Responses to Comments

# REZONE MAP

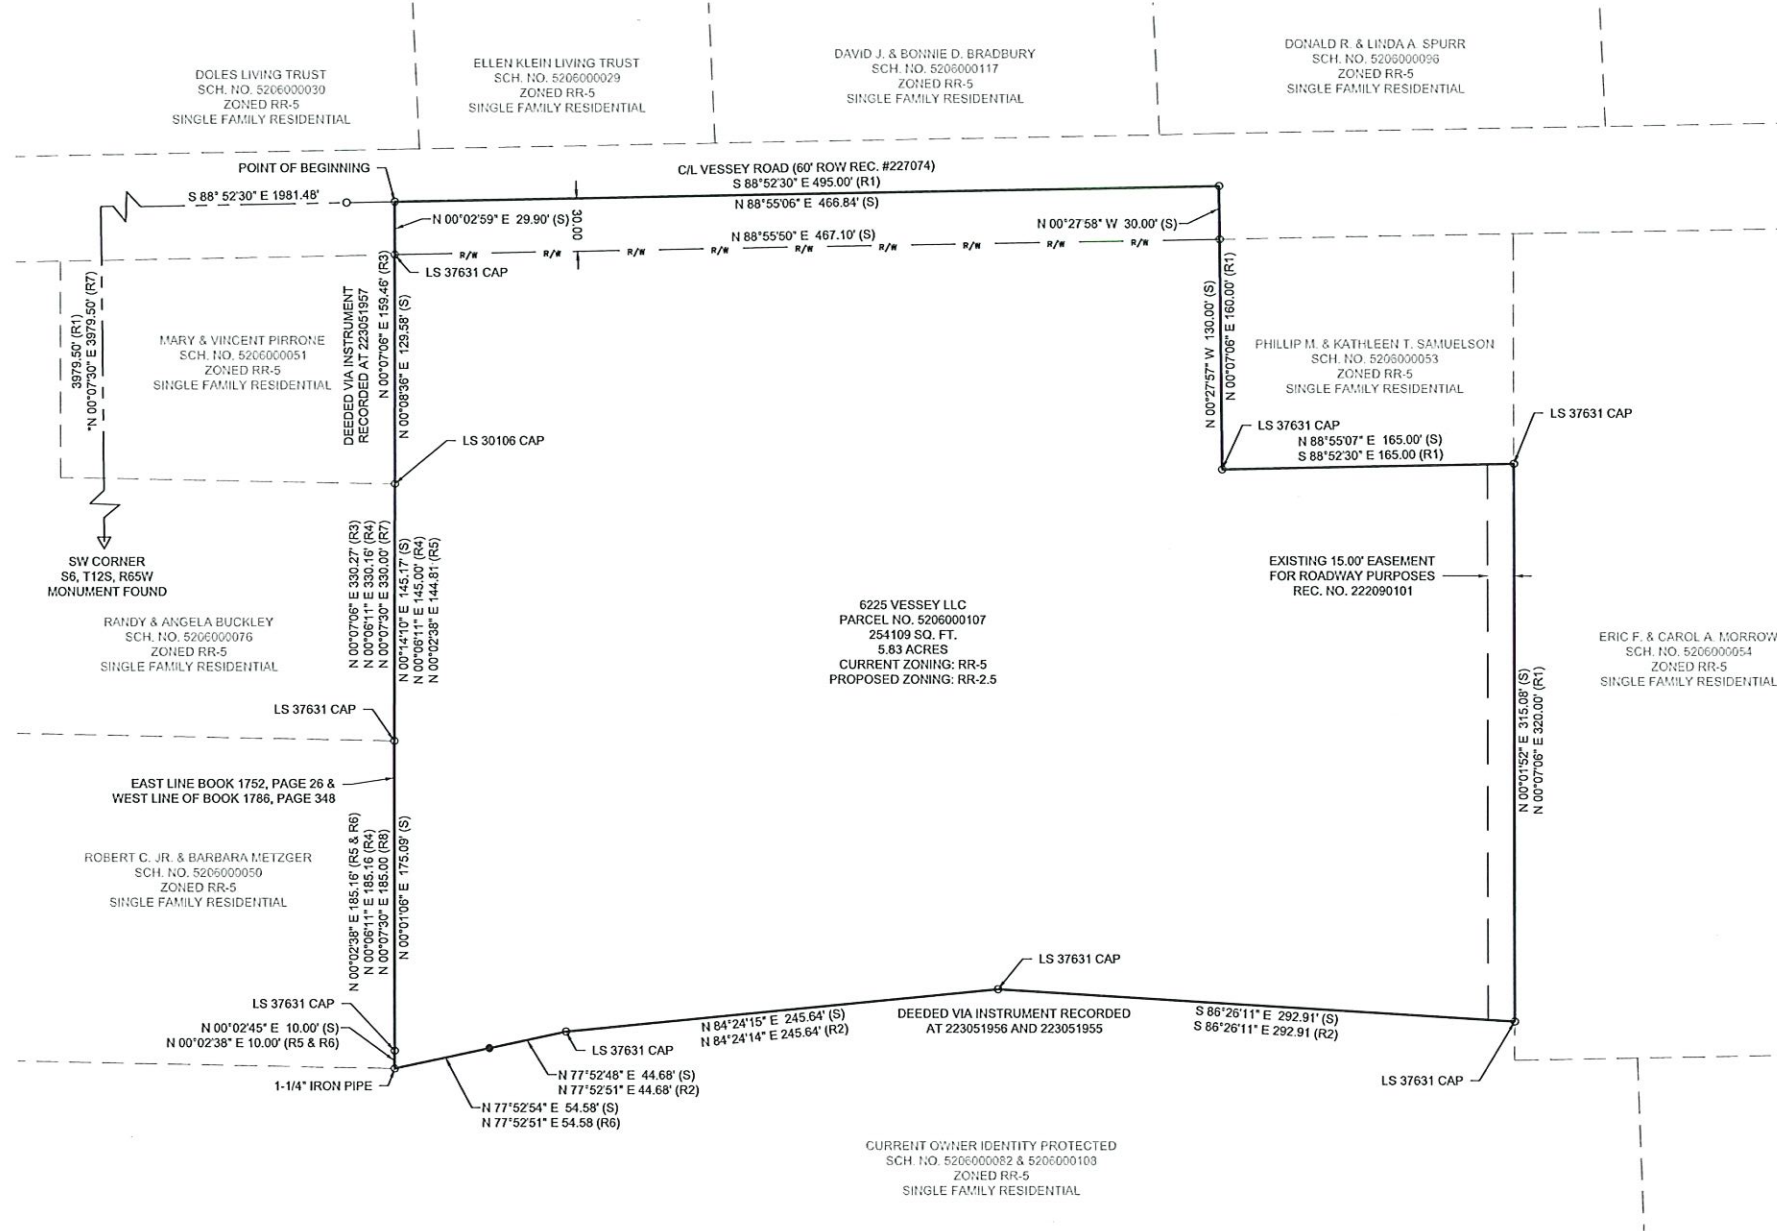
- Existing easements need to be depicted on map.
Easements have been added.
- Assessor's site does not include the road as a part of the parcel, please revise.
Revised.
- Lot configuration does not match our records, please revise, if correct please have a surveyor stamp and sign off on this.
The assessor's website is incorrect. There have been recorded quitclaim deeds altering the boundaries of the parcel that have not been reflected on the assessor's website. Copies of the recorded quit claim deeds have been included with the resubmission, along with surveyor's stamp.
- PCD File # P241
File Number has been added.
